From: [REDACTED]
To: [Hinckley SRFI](#)
Subject: Response to HNRFI additional information
Date: 04 February 2025 10:45:47

A summary of my feedback regarding the B4669 Hinckley Road/Leicester Road Sapcote issues is as follows:

A summary of my feedback regarding the proposed changes in the centre of Sapcote, surrounding the Co-Op is as follows:

Proposed Layout - School buses waiting in loading bay in front of Co-Op

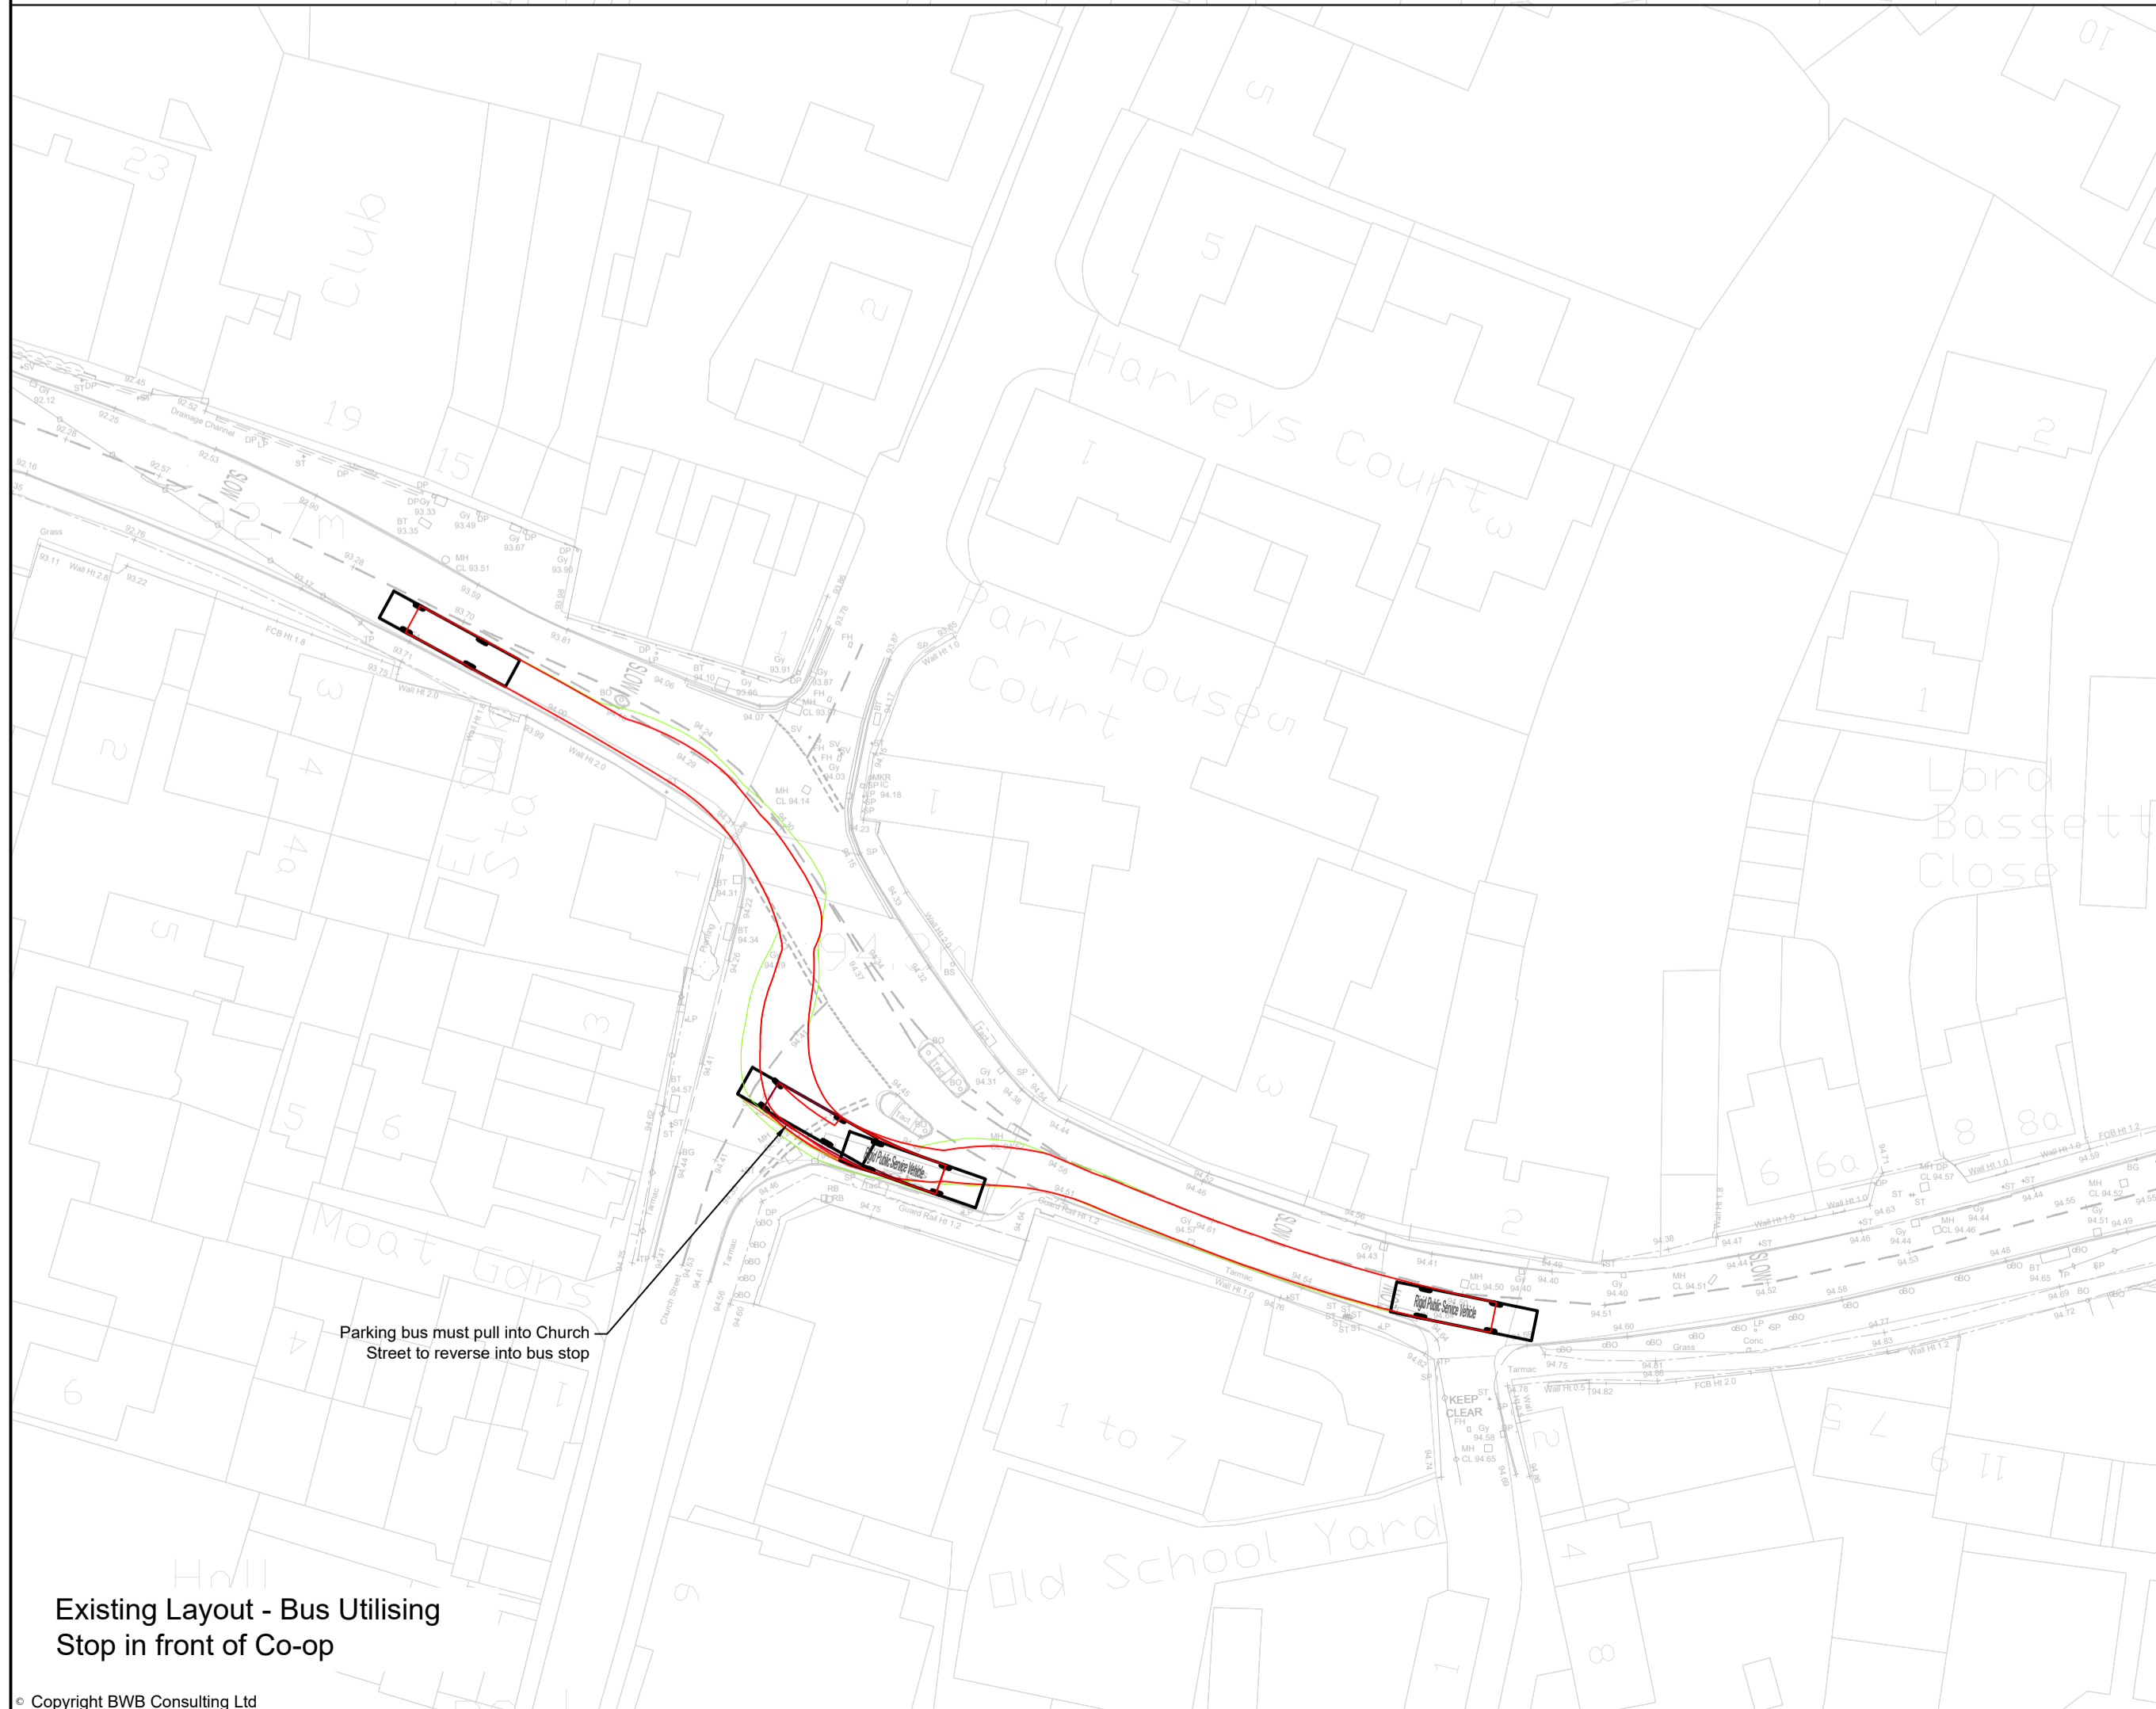
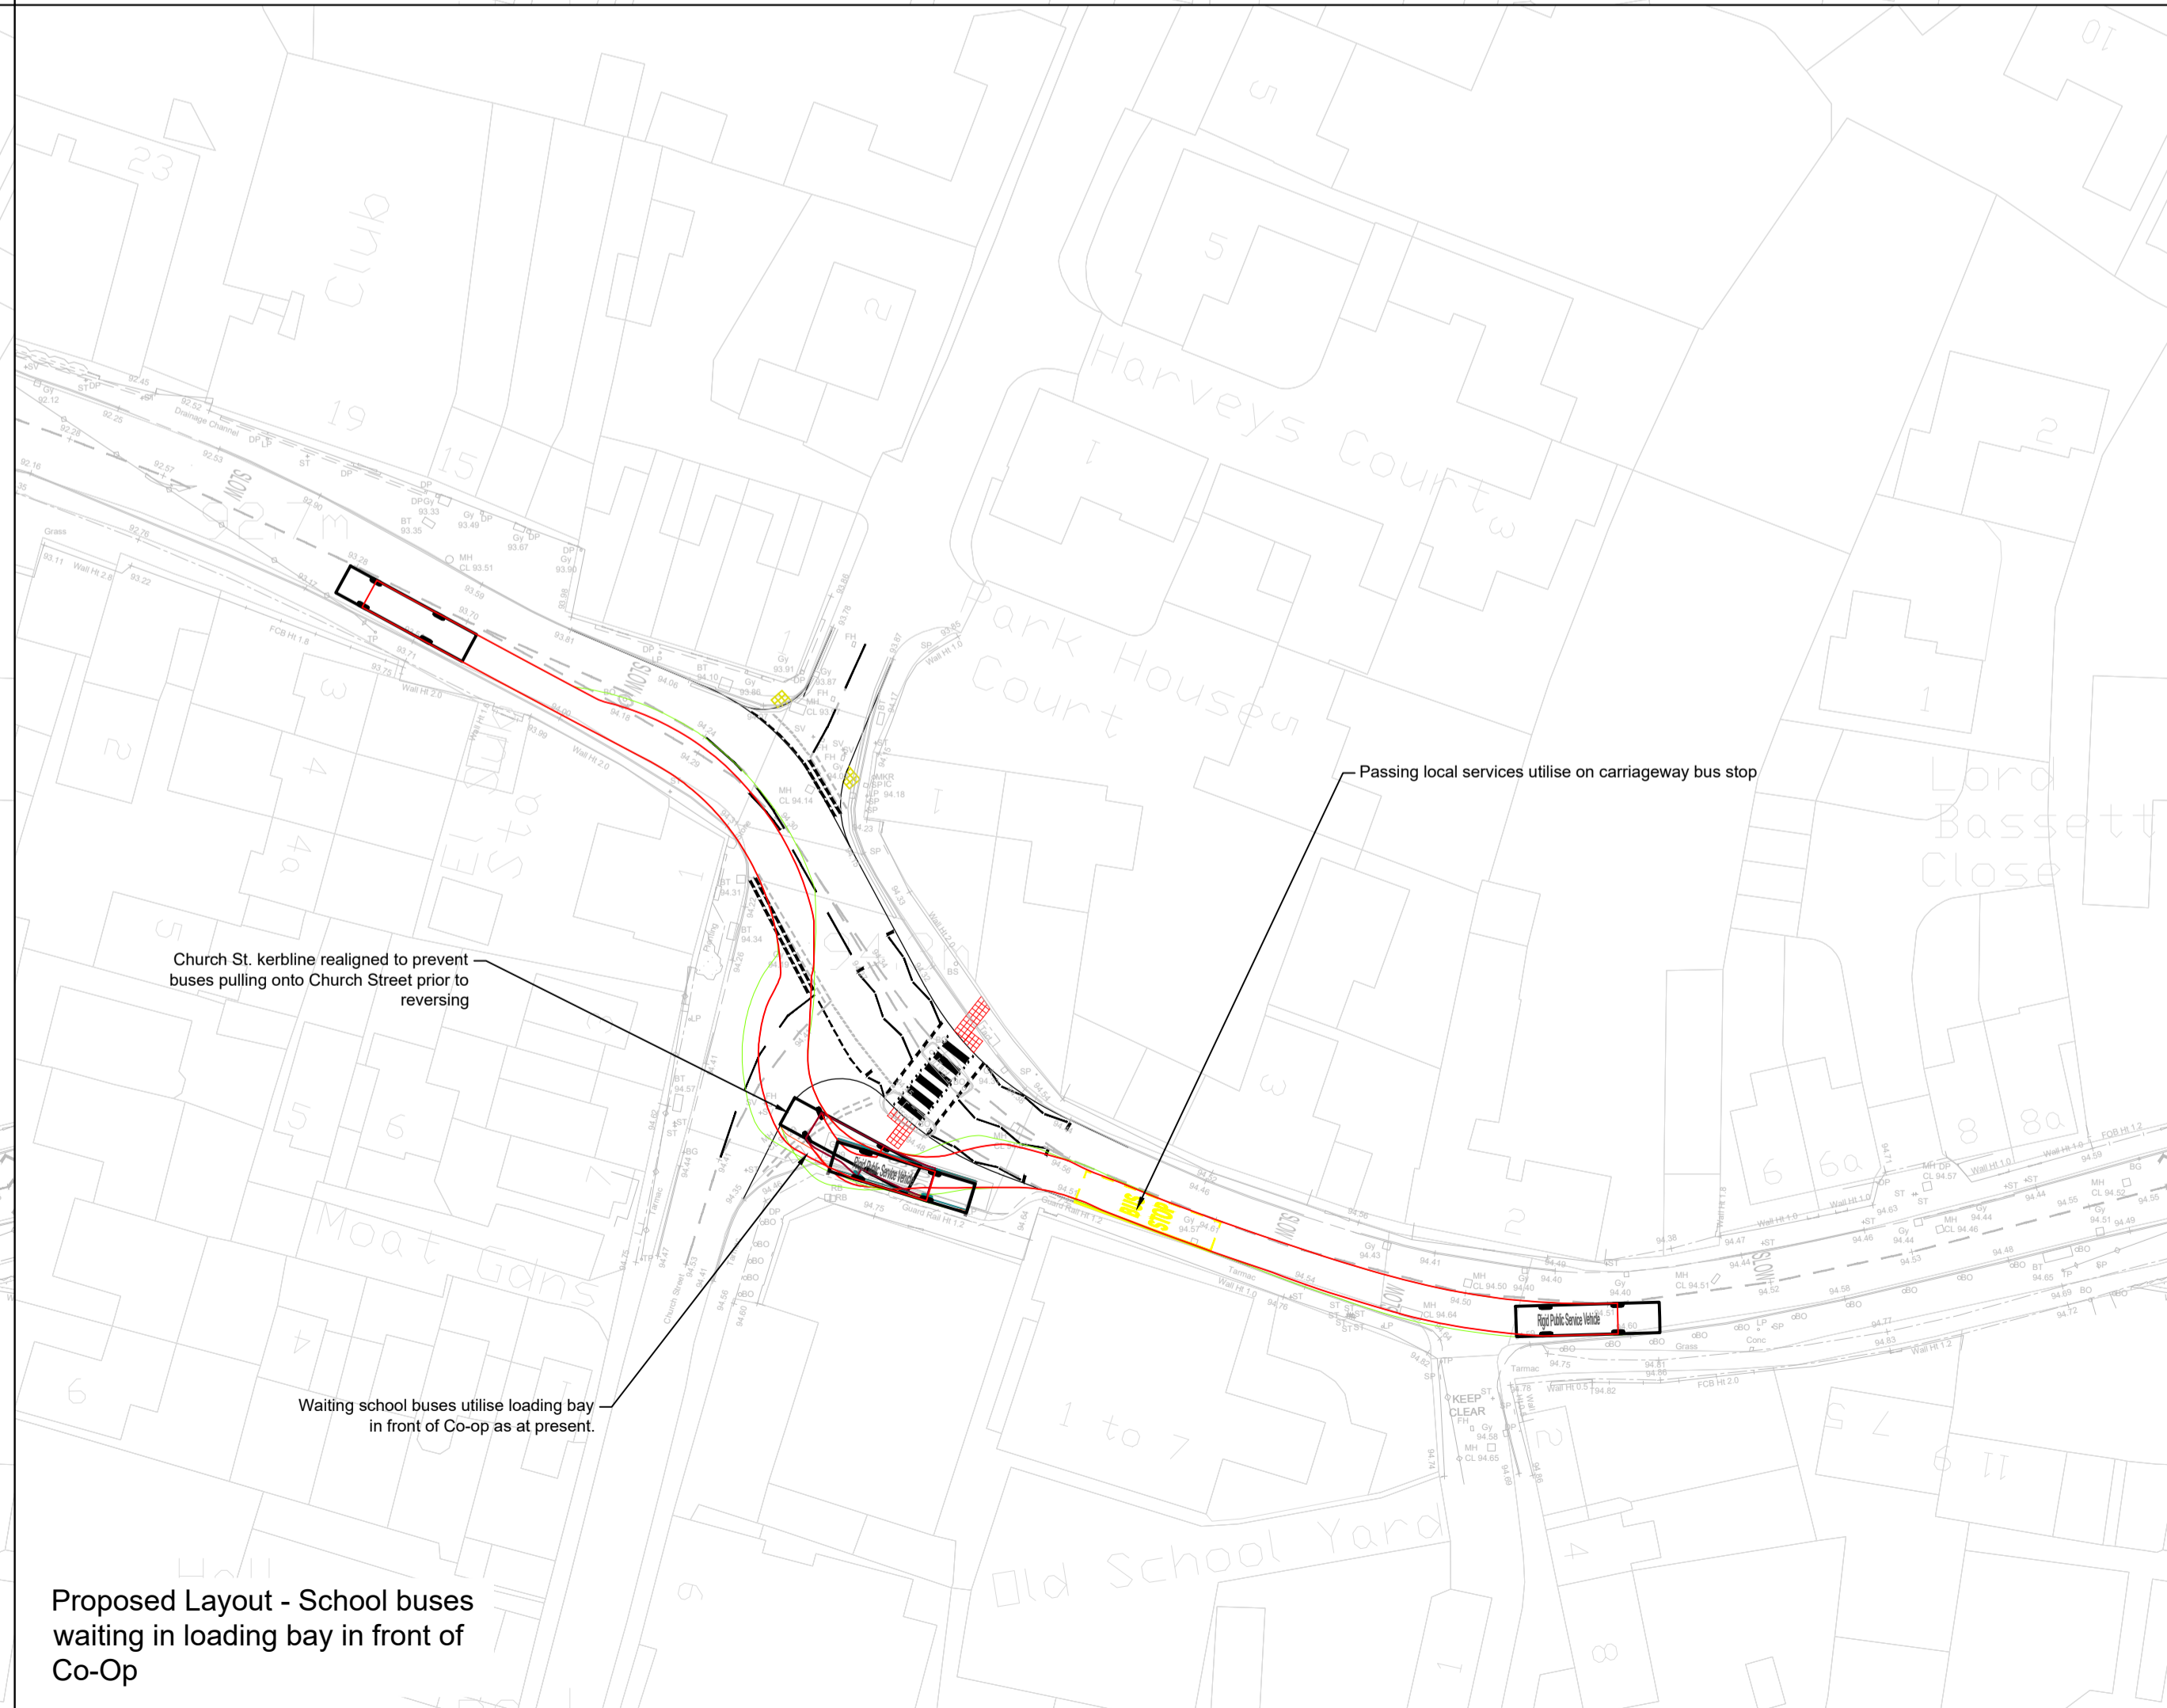
- Currently the bus stop outside the Co Op ensure children waiting for the school buses are away from the road on the side outside the Co Op. Moving the bus stop to a narrower part of pavement poses pedestrian congestion at times when there are children waiting for the bus, parents taking their children to the primary school on foot and other residents walking through the village. This will pose a risk of accidents

- Moving the bus stop into a lay-by has a number of concerns when a bus is in the lay-by it hides the oncoming traffic warning sign to other vehicles.
